Re: University Self Storage Drainage Plan

RE: Grading & Drainage Plan For University
Self Storage Site (J15-D21) Received April
6, 1984.

REF: REVISED GRADING AND DRAINAGE PLAN FOR UNIVERSITY SELF STORAGE
(J15-D21) RECEIVED MAY 3, 1984

DRAINAGE PLAN
FOR
UNIVERSITY SELF
STORAGE SITE

DRAINAGE PLAN

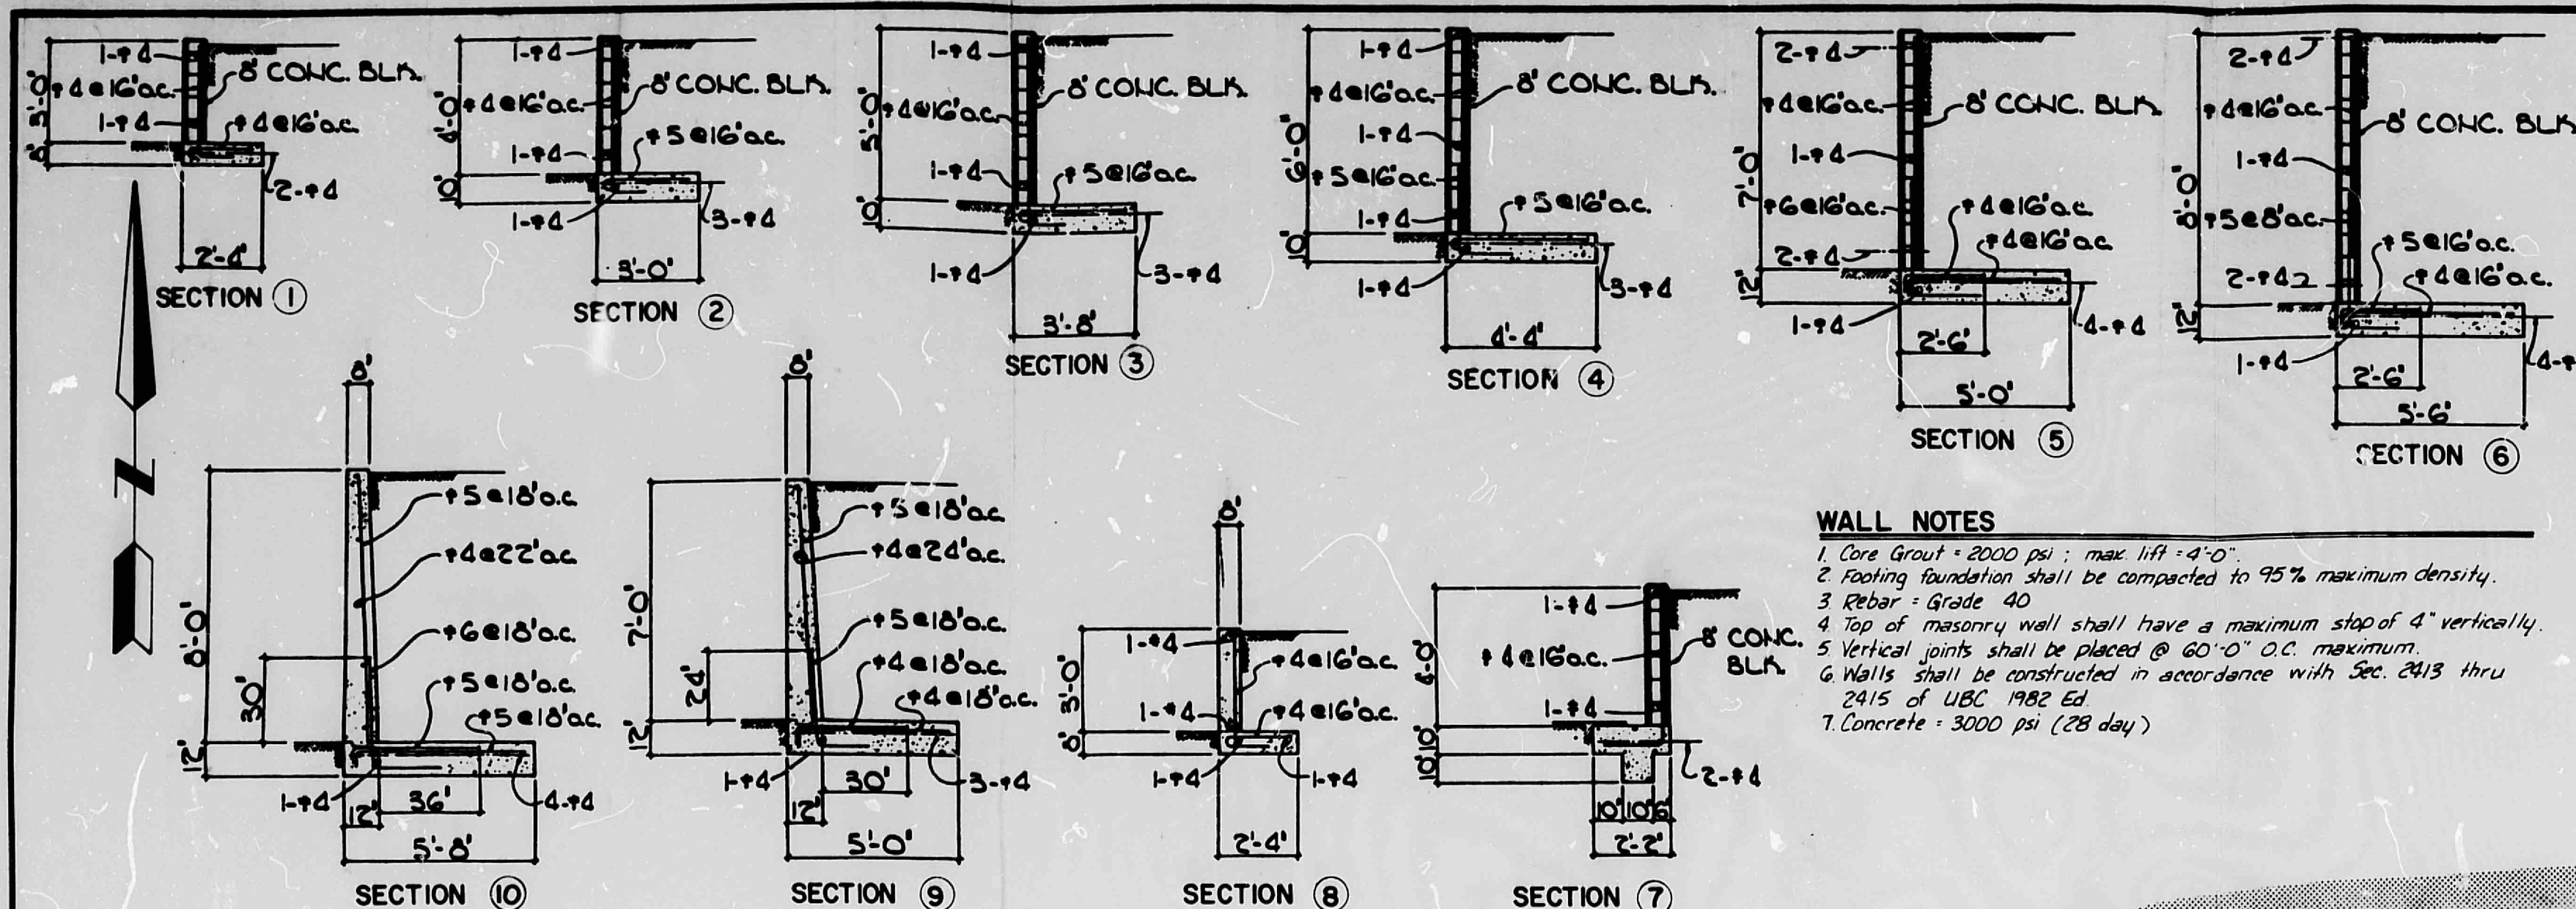
1. A soils report will be required
for the encroachment into the
flooding area in the street.
2. The ponding volume displaced
by the development will have to
be accounted for by either pond-
ing on-site (the ponding will also
have to contain on-site contribution)
or by providing a storm sewer
system for removal.

3. The structures in the eastern end of the property will have to be raised above the flood ponding elevation (BFE = 5082.00). It is also suggested that the entrance to the site be moved to the north and western portion of the site to allow for the elevation of the southeastern corner of the property where the entrance is currently proposed.

1. A soils report would be required outlining requirements for constructing any retaining walls adjacent to the flood pool.
2. Ponding should be provided for the amount of flood plain displaced by the project and for the runoff volume increase due to paving the west end of the project.
3. Off-site flows should be conveyed through the property by providing openings in the walls.

I have enclosed a revised report which supercedes our previous submittal. The above items have been addressed in the report.
